# **SSD 4651641 & SSD 10448 MOD3 – ASPECT INDUSTRIAL ESTATE WAREHOUSE 9**

## **OPERATIONAL DETAILS FOR WINNINGS – RESPONSE TO RFI**

### **1. REQUEST FOR INFORMATION**

Figure 3 Modified Warehouse 9 Layout

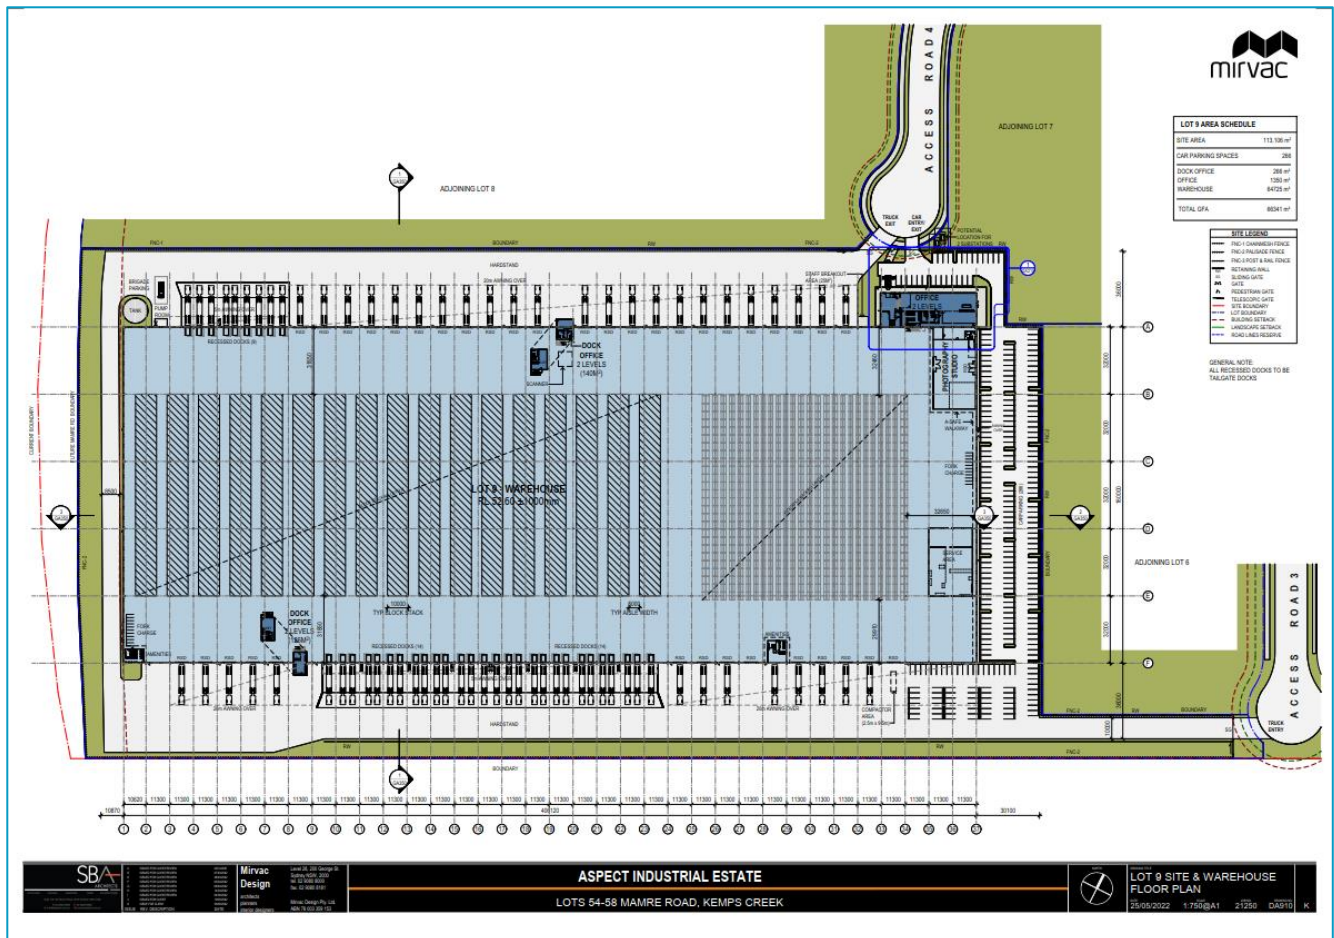
1. *Provide a detailed operational description (including any site plans) of the proposed development detailing the inbound /outbound activities of proposed light and heavy vehicles accessing the site.*
2. *Include a detailed description of the proposed handling and disposal of used appliances on the site, including daily volumes and frequency of waste removal. Provide a site plan indicating the location of the waste storage areas including the compactor.*

In response to Matter 1 above, it is confirmed that the Winnings loading/unloading operations at the proposed Warehouse 9 will be undertaken in the following manner: (See attached Lot 9 Operational Plan)

- All operational vehicles, including vans and heavy vehicles, will exit via Road 04.
- Inbound container deliveries will utilise the recessed docks at the north west corner of the warehouse (Dock A on the Operational Plan). Containers can be at the dock for up to 24 hours.

- Inbound fast moving goods – semi- trailers and rigid trucks will reverse up to on-grade docks for side unloading at the central northern part of the warehouse (Dock B on the Operational Plan). B-doubles will position themselves under the canopy for side unloading.

- Inbound slow-moving goods - semi trailers and rigid trucks will reverse up to on-grade docks for side unloading at the north east part of the warehouse (Dock C on the Operational Plan). B-doubles will position themselves under the canopy.

- Outbound vehicles (vans) will utilise on-grade docks for appliance installations to collect appliances, electrical and plumbing equipment at the south west part of the warehouse (Dock D on the Operational Plan)

- Outbound vehicles (rigid trucks) utilise the recessed docks at the centre of the southern elevation to collect the appliances for customers or retail outlets (Dock E on the Operational Plan).

- On-grade docks at the centre of the southern elevation. are utilised for miscellaneous activities and contingency in the event that the on-grade docks at the south east and south west corners are congested (Dock F on the Operational Plan).

- Outbound vehicles will unload old and faulty appliances at the south east recessed dock (Dock G on the Operational Plan).
- All operational vehicles (vans and heavy vehicles) will access the site via the truck entry from Road 03 and move around the site in a clockwise and forward direction, and will exit the site via Road 4.

- Winning will have a general waste (non-putrescible waste) compactor as shown on the plan. General waste includes packaging materials (plastic wrap, bubble wrap, etc).

- Winning will have a cardboard compactor that will be located internally to the warehouse.
- The general waste compactor will be located at the south east corner of the warehouse as shown on the Operational Plan, and the cardboard compactor will be located internally to the warehouse.

- The skip bin storage is located at the south east corner of the warehouse as identified on the Operational Plan.
- The 3 x skip bins are removed and replaced (removal and replacement of each skip bin is done in a single trip) daily between the hours of 7am – 12pm.
